KIRKLEES METROPOLITAN COUNCIL INVESTMENT & REGENERATION SERVICE

DELEGATED DECISION TO DETERMINE PLANNING APPLICATIONS

Reference No:	2026/62/90619/W
Site Address:	United Church Marsden, Warehouse Hill Road, Marsden, Huddersfield, HD7 6AB
Description:	Change of use and alterations to church (class F1) and Sunday school to form 8 residential units (class C3), including internal reconfiguration and external alterations, insertion of rooflights and formation of roof terrace, associated parking, landscaping and ancillary work. (within a Conservation Area)
Recommending Officer:	Danielle Cooper

Officer Report – 2026/90619

SIDE WINDOW CONSERVATION STRATEGY | INDICATIVE DESIGN PRINCIPLE

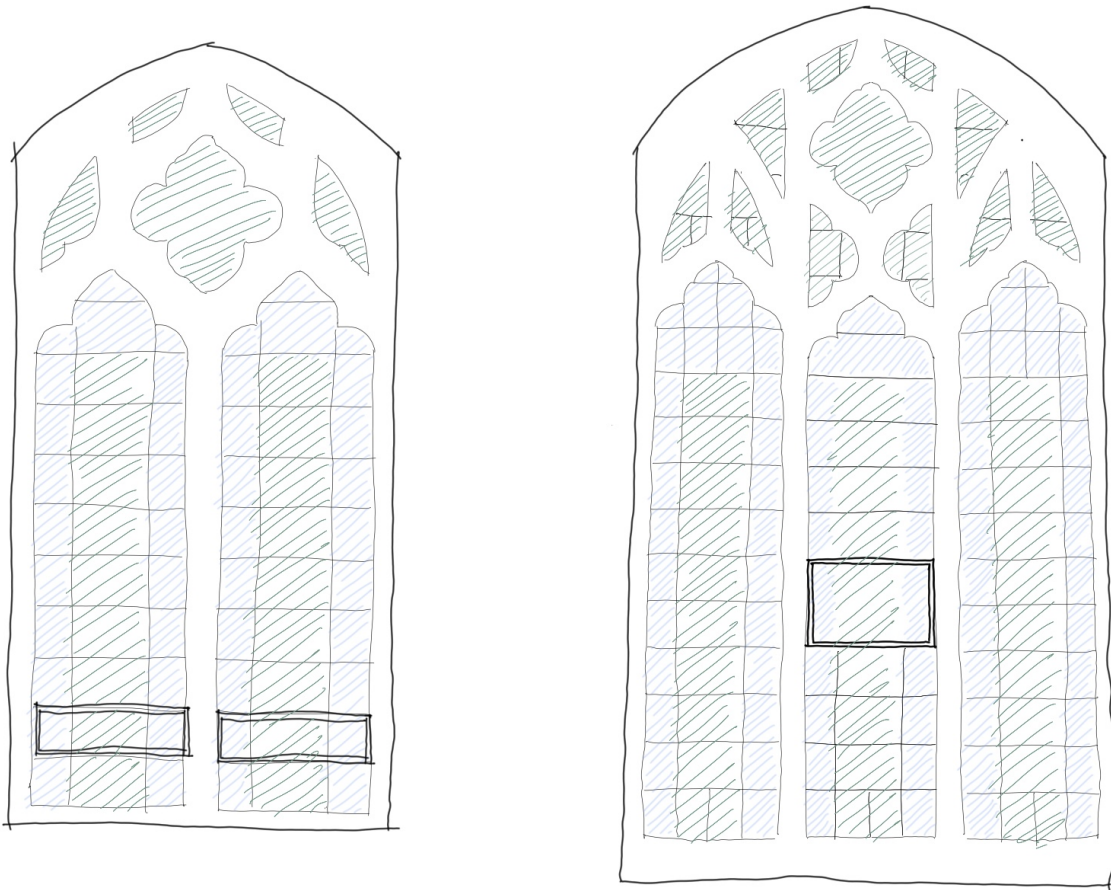
The other stained windows on the building will be replaced. Conservation and Design noted that to protect visual amenity, it is important to retain the original

stone tracery and stained-glass windows as they make a positive contribution to the character of the non-designated heritage asset and the conservation area. As such, the agent has proposed that they will retain the original stone tracery, encapsulate and reuse the stained glass within the lower section of the windows, and introduce a limited amount of clear glazing at the upper level for natural light and selected upper sections to be openable to provide the necessary ventilation. Conservation and Design have confirmed they are satisfied with this approach, as it will protect some of the historic fabric of the building. A condition will be imposed to ensure full details, sections, materials and methods of encapsulation of all replacement windows are submitted prior to commencement of these works. This is to ensure visual amenity of the building is protected.
